KITTITAS COUNTY

MEMORANDUM

TO: All Staff
FROM: Public Works Plan Review Team
DATE: April 4, 2025- SURVEY UPDATE April 22, 2025
SUBJECT: LPF-25-00002 Sasse

SASSE RIDGE PLAT

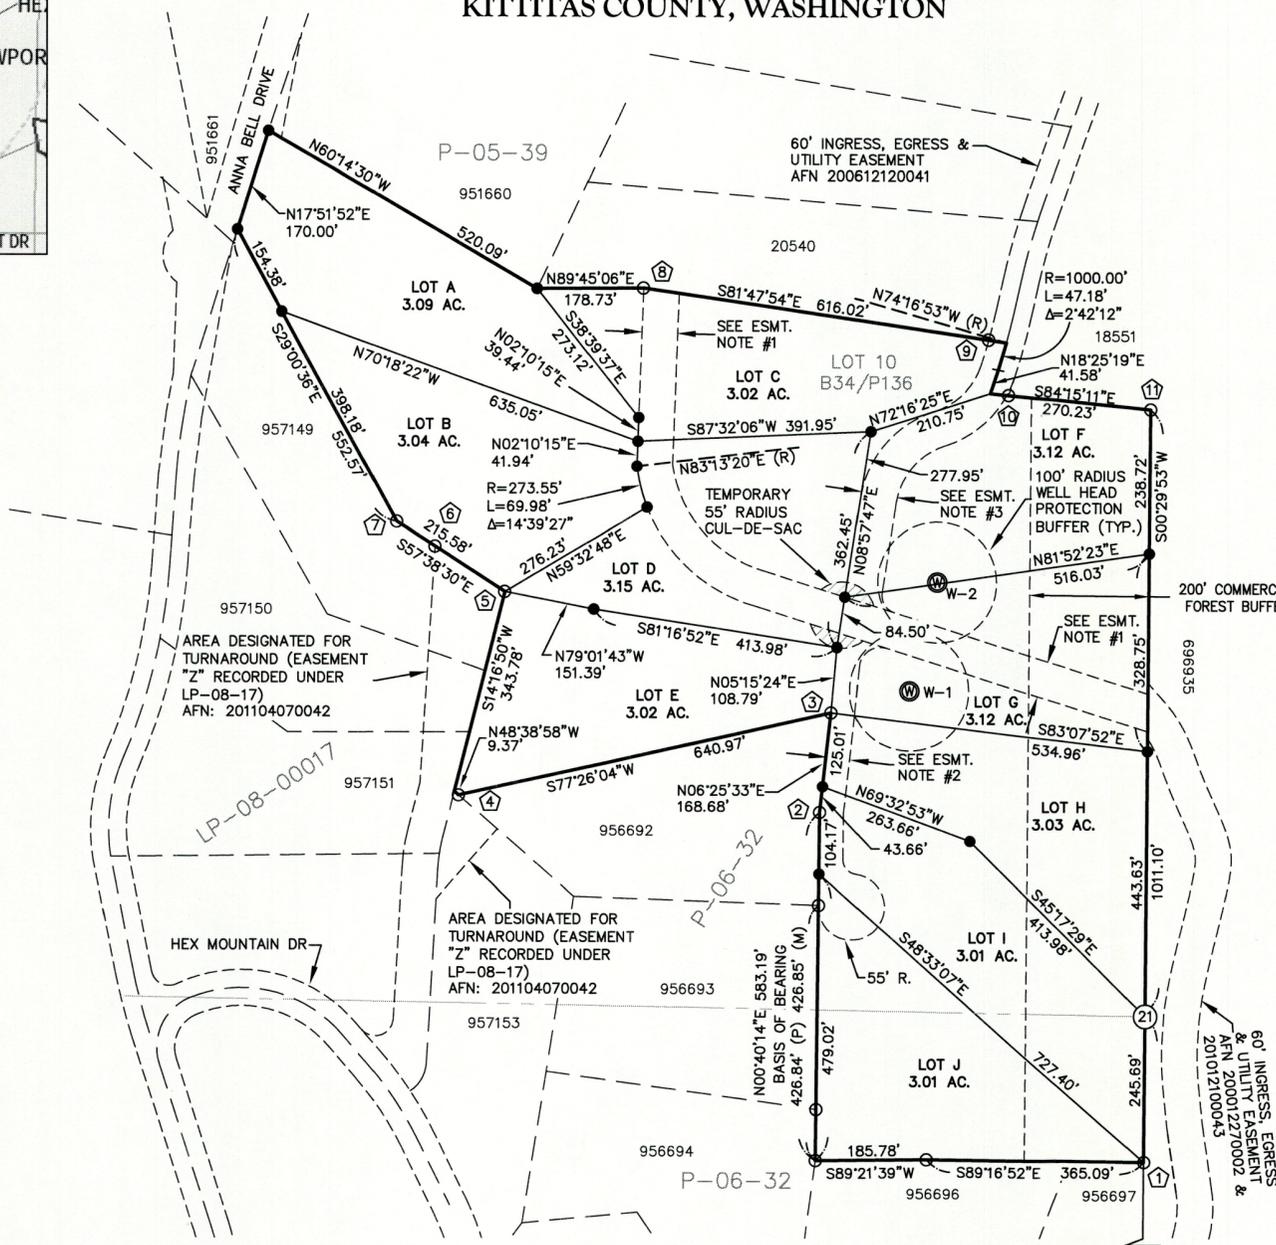
hundred (500) cubic yards shall be accompanied by an engineered grading plan (KCC 14.05.080). (CC)
SURVEY	<ol style="list-style-type: none"> 1. Easements S, T and U shall be denoted as to if they are existing, herein created, or created via separate document. If they are existing, include reference to the document recording number. If they are herein dedicated, they need to be retraceable, either by including metes and bounds, or including language "centered about existing road" (or similar). 2. The areas denoted as "Temporary 55' Radius Cul De Sac" needs to address whether it is existing, herein dedicated, or to be created via separate document. If existing, include reference to the recording number, if herein dedicated, it needs sufficient data for mathematical retracement. Please address the temporary nature, via a note detailing what action would terminate the easement. 3. Please label roads with R/W width, ownership and surfacing (EX: Anna Bell Drive-60' Private R/W-Paved) <p>UPDATE 04/22/2025 All prior comments have been addressed.</p> <p>As no substantive changes were made from the prior submittal, the following comments are to be considered as guidance only and not requirements. The fact these elements were missed on a prior review should not unnecessarily burden the applicant.</p> <ol style="list-style-type: none"> 4. Survey reference to Book 6 of Plats, Page 32 is incorrect. This should be "Book 11 of Plats, Page 247, AFN:201006210063" 5. Corners identified as 9 and 10, should show witness distance to true corner, as this was never identified on prior surveys. 6. Show what was found or set at the center of Section 21. 7. If the found property corner located just North of the Southwest corner of Lot J was utilized for survey control, it should include distance ties suitable for retracement. (JT)
